Appeal Decision

Appeal Ref: APP/R4408/D/25/3373917

3 Rydal Close, Penistone, Barnsley, S36 8HN

- The appeal is made under section 78 of the Town and Country Planning Act 1990 (as amended) against a refusal to grant planning permission.
 - The appeal is made by Jeremy and Louise Godley against the decision of Barnsley Metropolitan Borough Council.
 - The application Ref is 2025/0270.
 - The development proposed is a first floor extension, two storey side extension, single storey front extension, demolish existing garage and construct double garage, convert garage, alterations to drives, alterations to fenestration and doors, new boundary walls/fencing.
-

Site Plans - PROPOSED

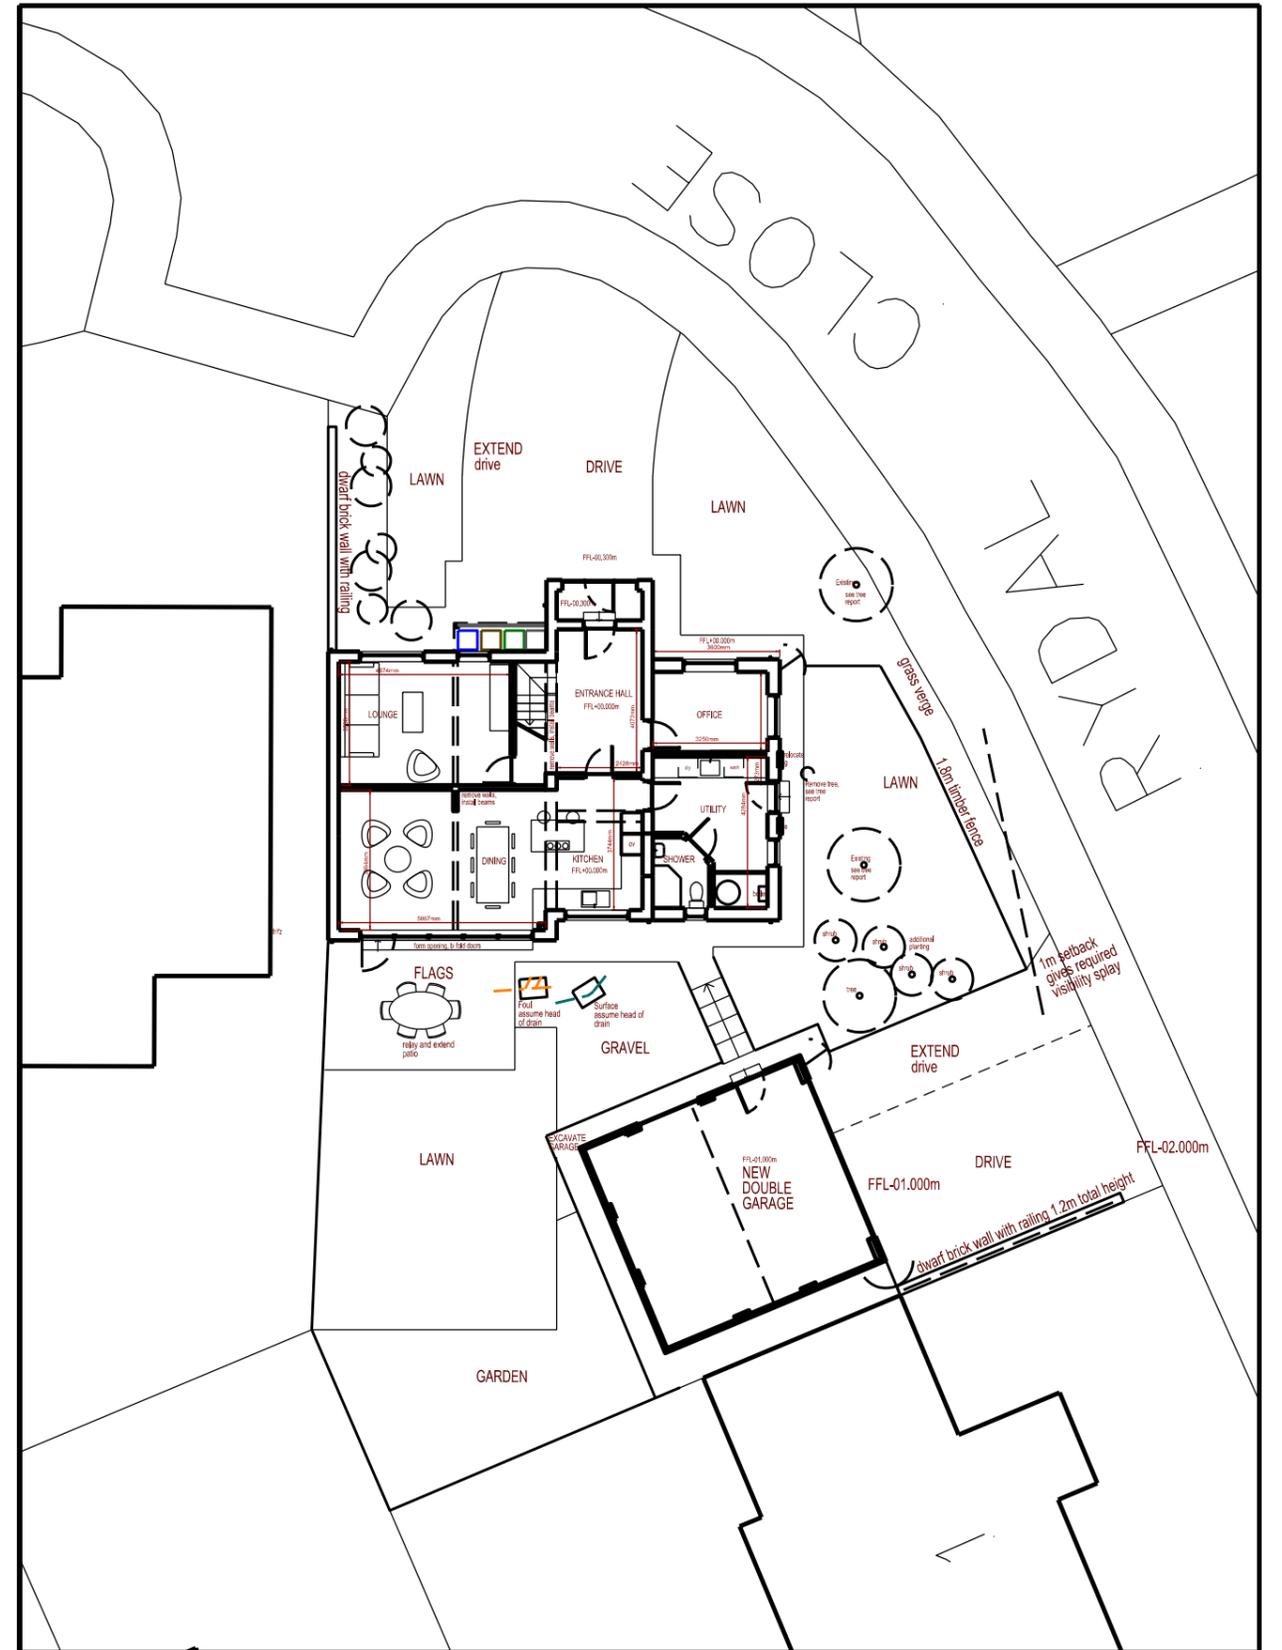
15. Further, by extending into the appeal property's side garden area, the proposal would severely erode that part of the appeal property's positive contribution to the area's identified green and spacious attributes. The harm arising from this would be exacerbated by the proposed fence, which would appear as an unduly tall, prominent and obtrusive feature, out of keeping with the area's more open and spacious qualities.

Drawing Title: Elevations - PROPOSED

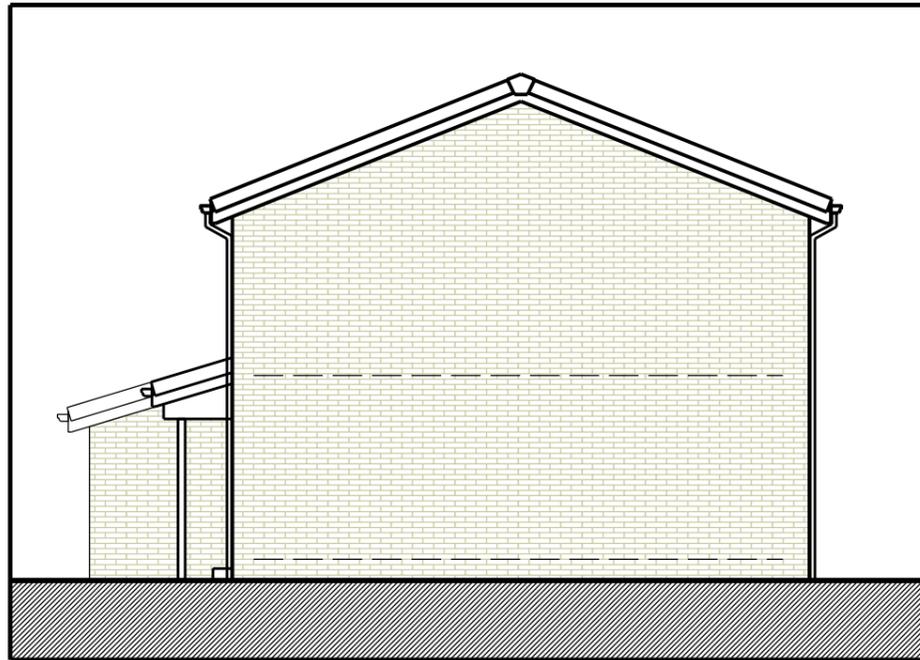
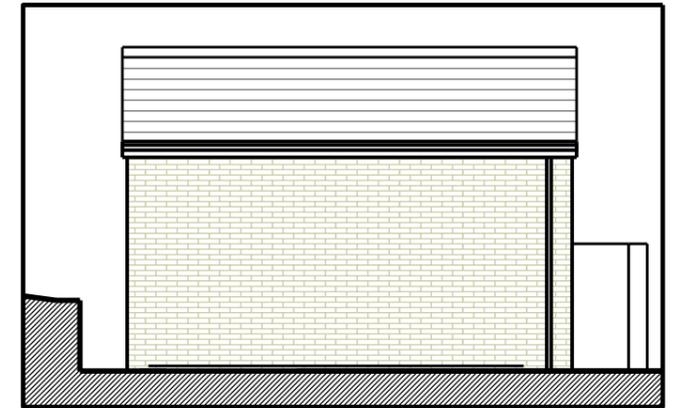
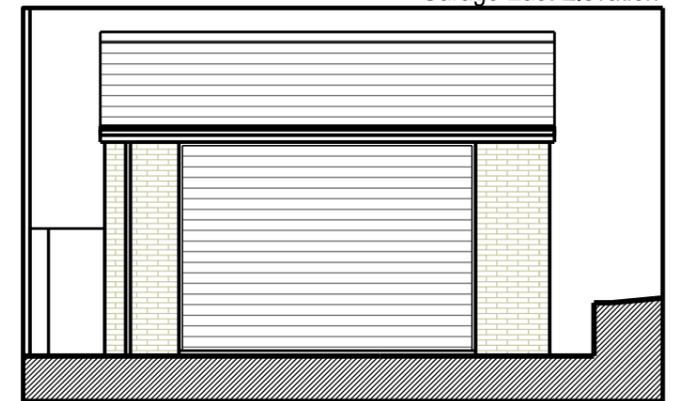
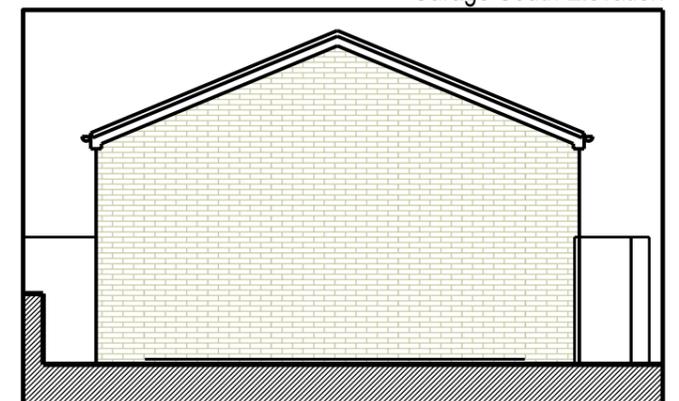
12. The proposed development would extend the appeal dwelling to the side across two stories. I find that this would result in the host dwelling appearing excessively tall and wide on its plot, in a manner that would appear out of character with neighbouring dwellings, not least due to the visually awkward fenestration and staggered form of development proposed.

13. The harmful visual effect of this would be exacerbated by the tall, two storey height of the proposal, along with its projection along the majority of the length of the dwelling, such that it would comprise a large and bulky addition. The visual harm arising from this would be emphasised by an unbalanced effect resulting from the stepping down of the proposed roof.

14. In addition to the above, I also find that the siting of the proposed side extension, in a prominent corner location widely visible in its surroundings, would result in it drawing undue attention to itself as a large and incongruous addition.
